Application for a Non-Material Amendment Following a Grant of Planning Permission

54814/APP/2017/604

Amendment to Condition 11 - No more than 2,600 Development Units shall be occupied prior to the bringing into use for general traffic of the Pump Lane Access works as shown on Drawings No 52212/B/33 and 52212/B/34 unless otherwise agreed in writing by the London Borough of Hillingdon as the local planning authority in consultation with Transport for London.

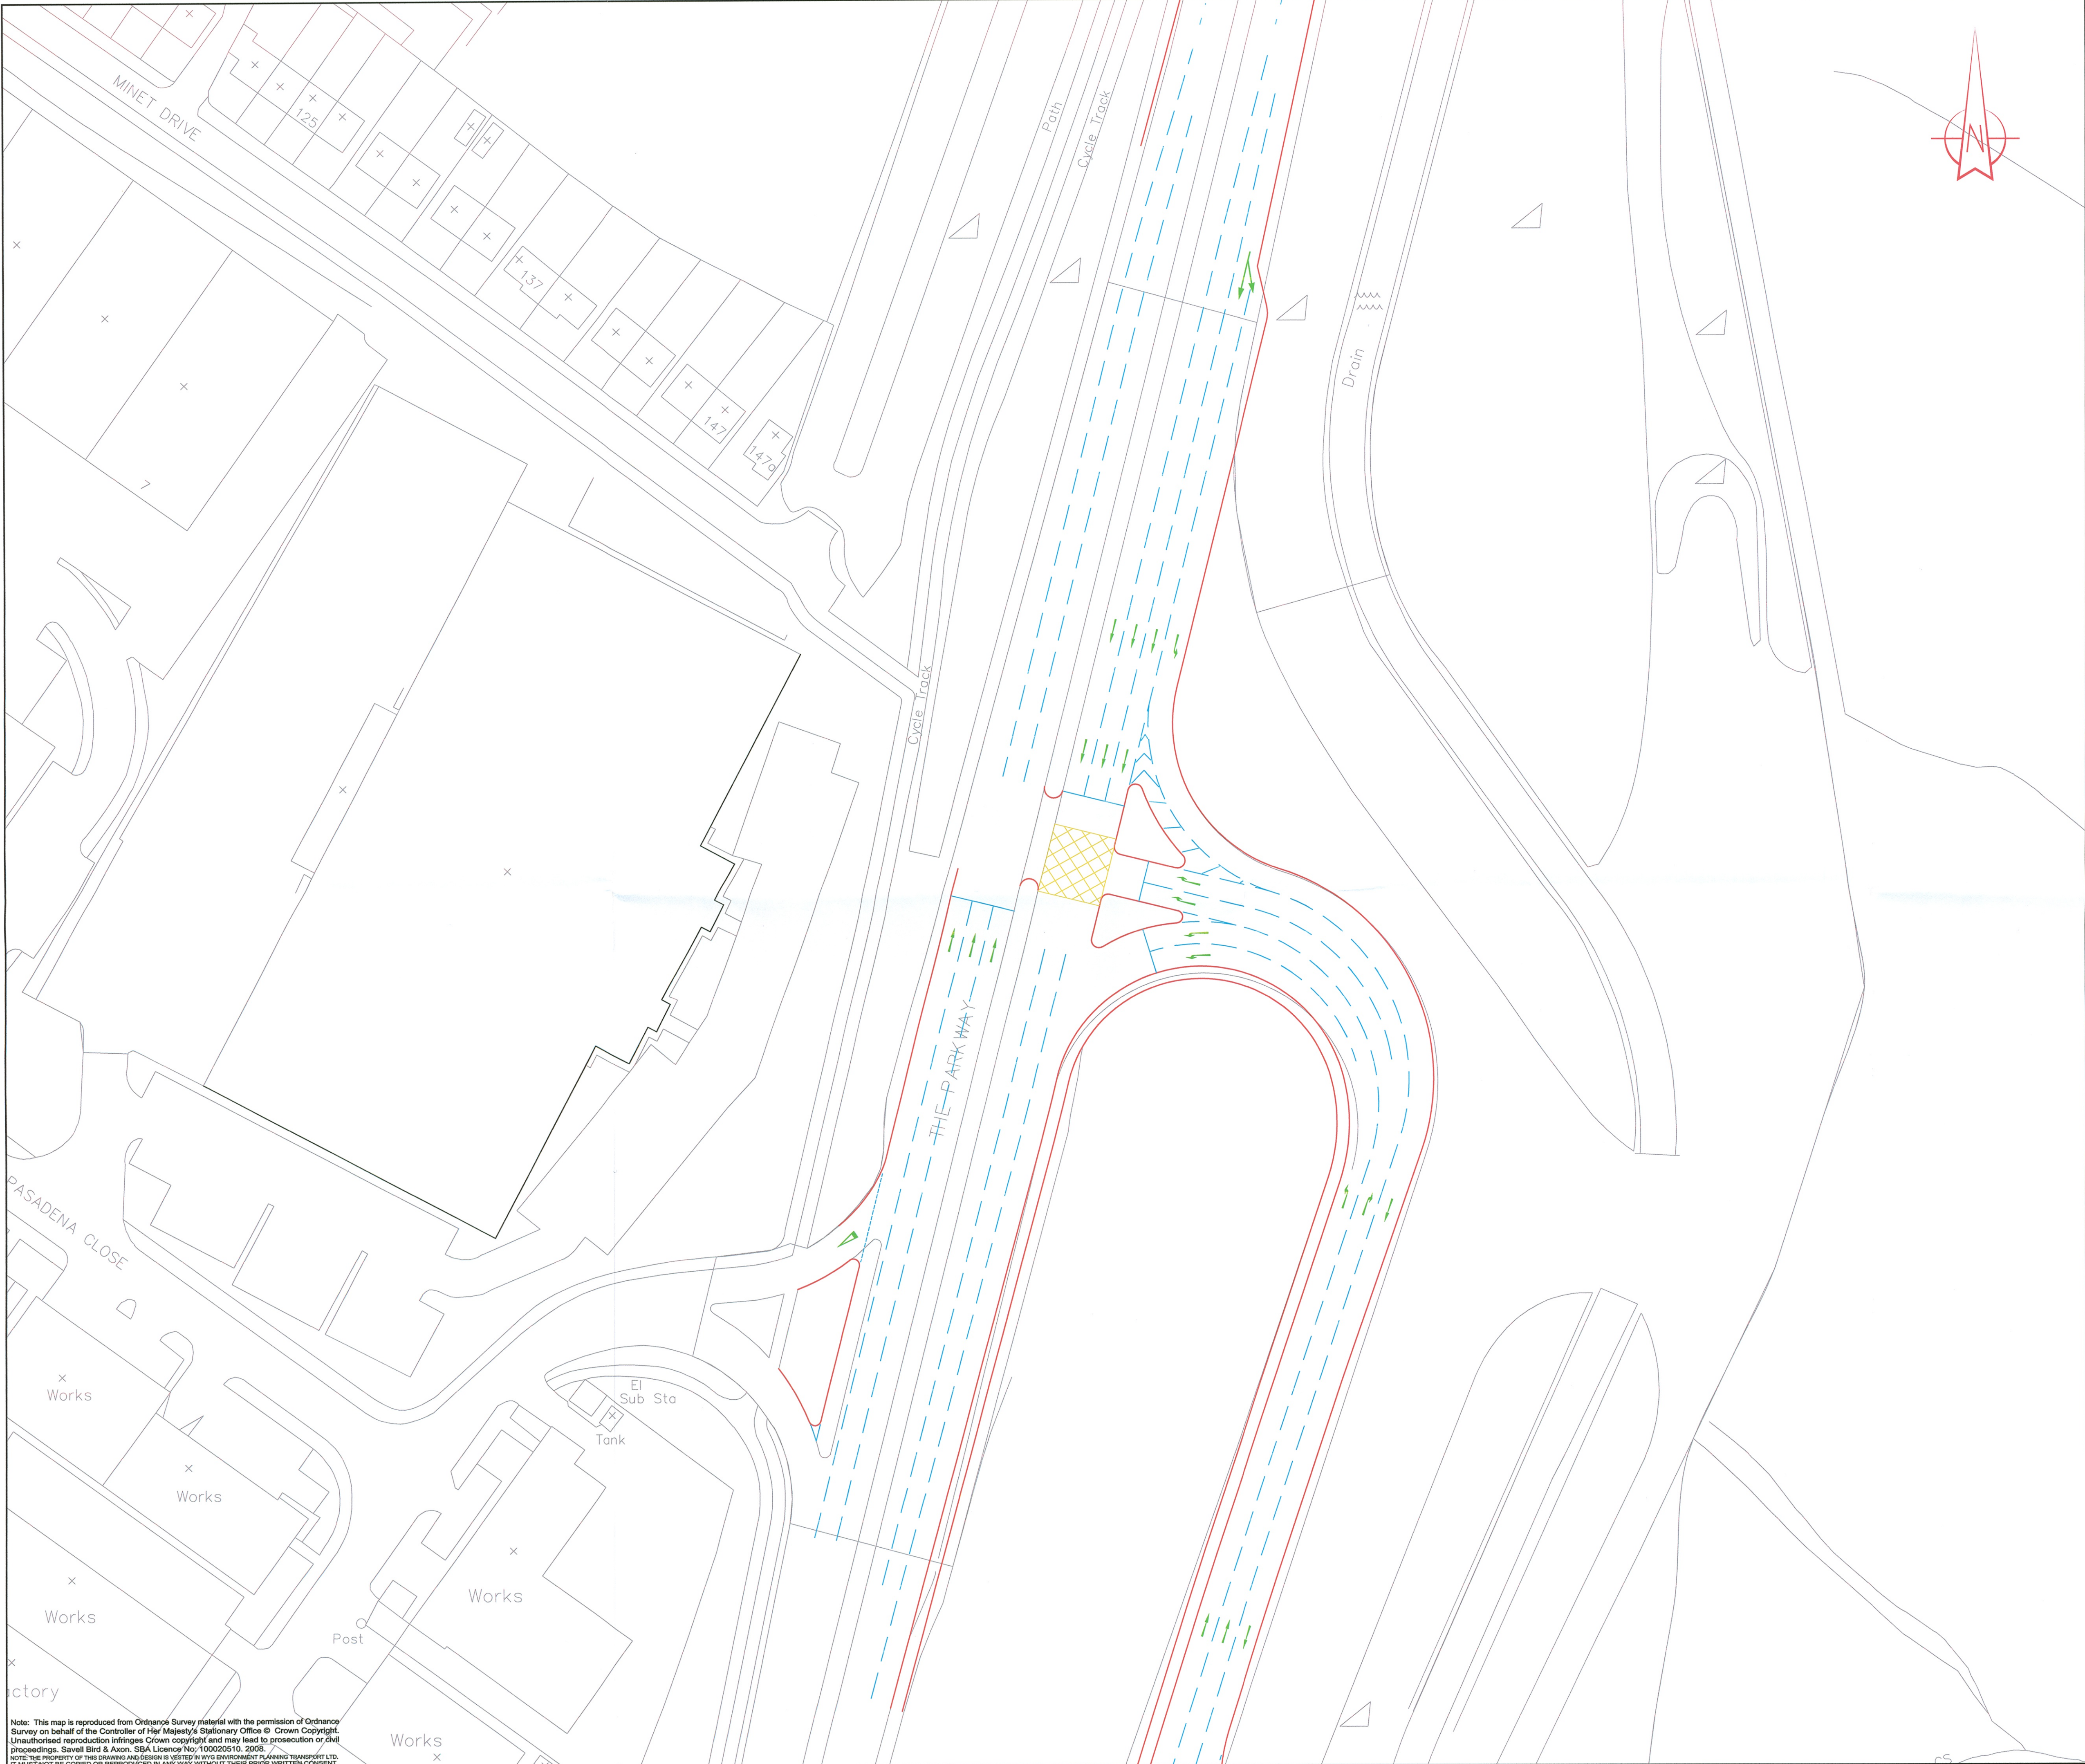
Condition 11 requires completion of off-site highway works to the A312 at Pump Lane as directed in Plan 52212/B/34/A. TfL have completed modelling and determined that the junction is not required, condition 11 requires amendment to remove reference to Plan 52212/B/34/A with the rationale set out below.

On 18/11/24, an email received by TfL Pump Lane, Bilton Way and A312 Proposed Junctions included a document labelled Pump Lane NPD Comment 28-02-2024 which concluded the following: The current option presented to TfL does not include any changes to the junction of A312 and Pump Lane on/off slips. As such this has not been assessed by TfL NPD. The LinSig and VISSIM modelling that has been undertaken has assessed the proposals at Pump Lane

/ Access and Bilton Way / Pump Lane. Both of these schemes have been approved by TfL NPD. TfL NPD satisfied that the current proposal is appropriate and that the proposal to signalise the junction of Pump Lane and A312 can be omitted from the scheme. The document is included within this planning application
